Ref: R/184/17/PD

I wish to place an objection to the proposed change of use of No.51 Sea Lane from retail to a restaurant/cafe. We already have four food/restaurant outlets between Cudlow Avenue and the Street plus the Lamb Public House just around the corner in the Street ie: Honeypot Cafe, the Mick's Fish & Chip Shop. Tandoori Nights and Pacettis in Sea Lane opposite the Church. Frequently when the wind is in the north west we can smell the fumes from the Curry House which can be most objectionable and a cafe/restaurant even closer with a prevailing west wind we would get continual cooking smells. Rustington has had two new eating places opened in the last few months and now the proportion of cafe/restaurants to other shops in the Village is overwhelming.

**APPENDIX ONE:
DRAWING SHOWING EXTERNAL EXTRACT AND VENTILATION EQUIPMENT PROPOSED**

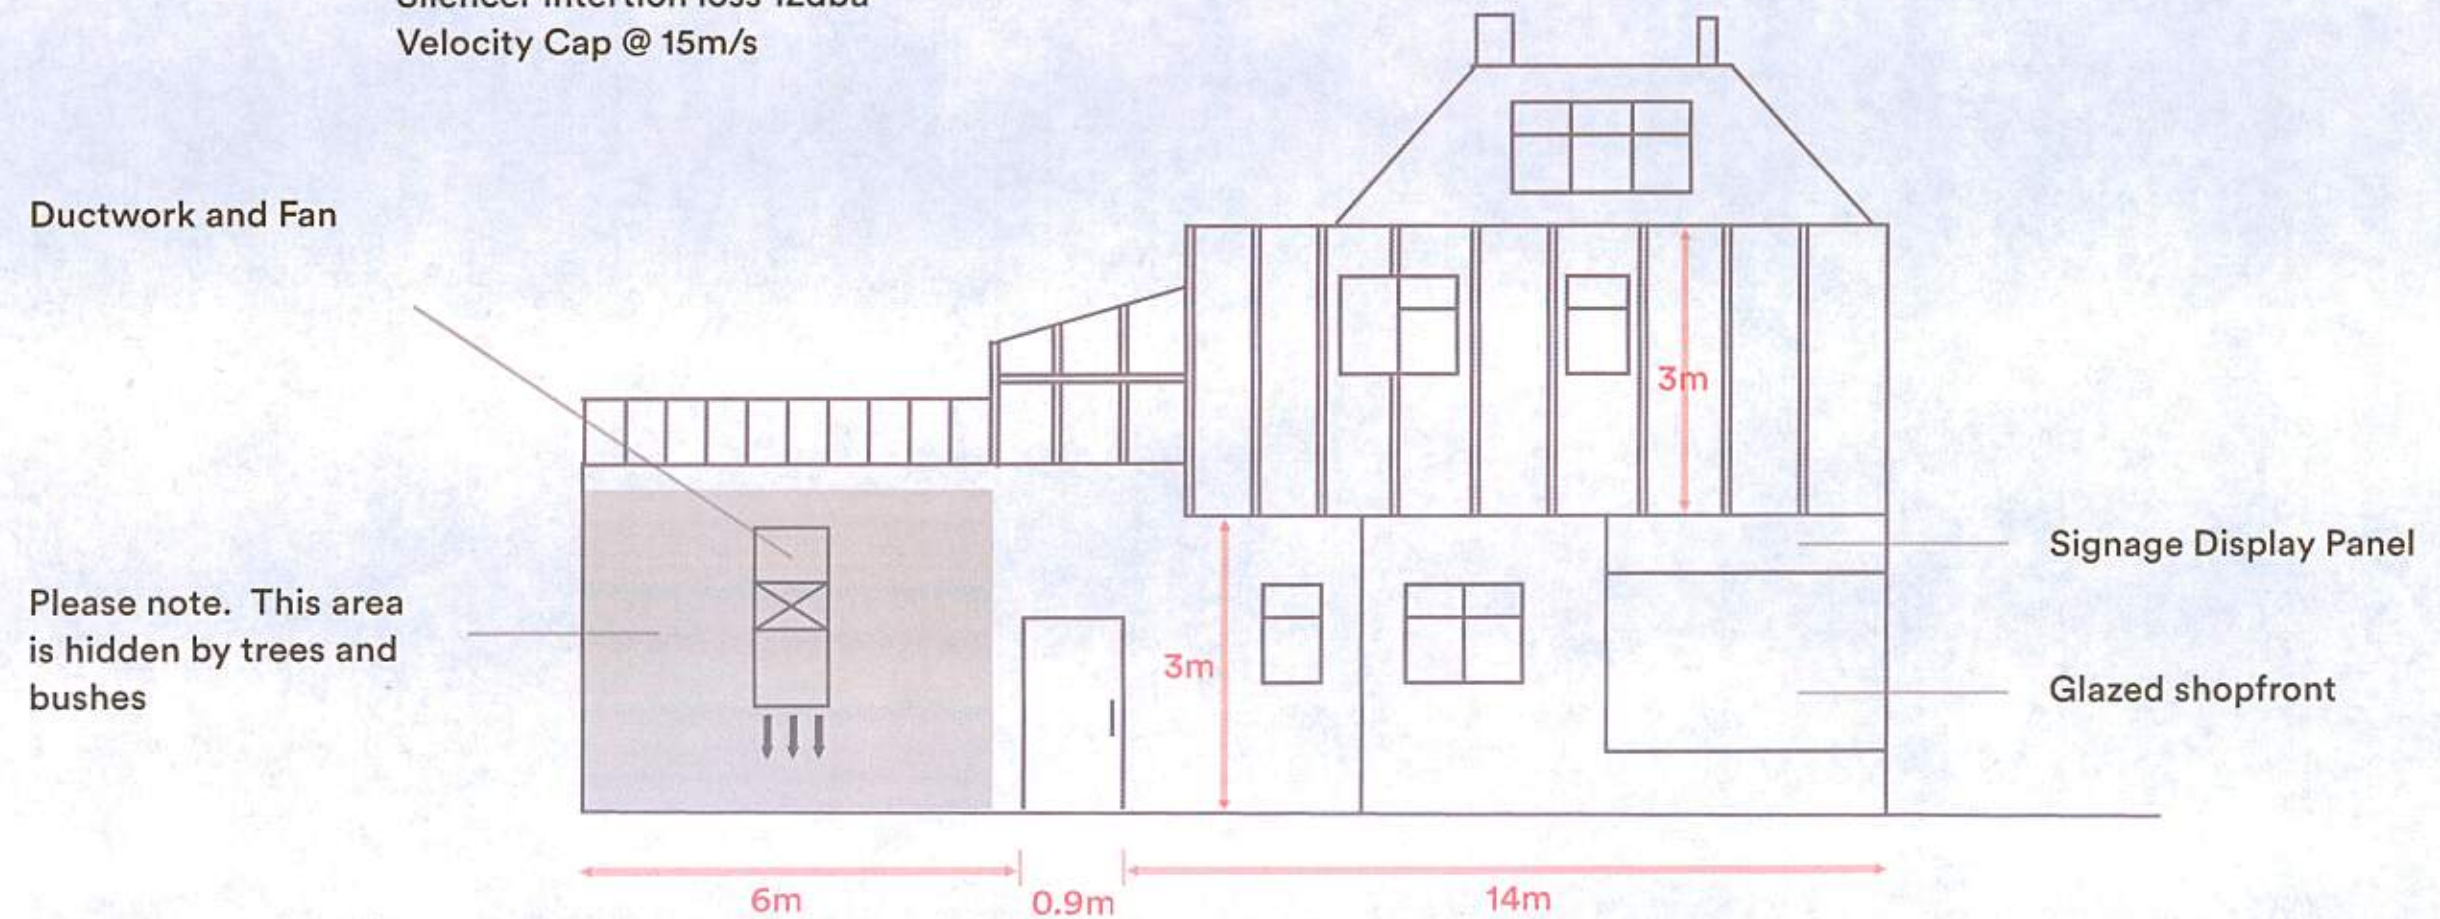
1. The parking bay outside 51 Sea Lane is small and is for short time parking
2. Cudlow Avenue is a private road so cars parking for the restaurant cannot park in our road
3. The road narrows at this point and it is extremely difficult to see oncoming traffic when exiting Cudlow Avenue and continual parking in the bay will make it more difficult
4. Car drivers will use our private road as a short cut
5. There is no fenced off area behind the shop to put waste material
6. With a prevailing west wind we shall be continually in line with the cooking smells from a extractor fan
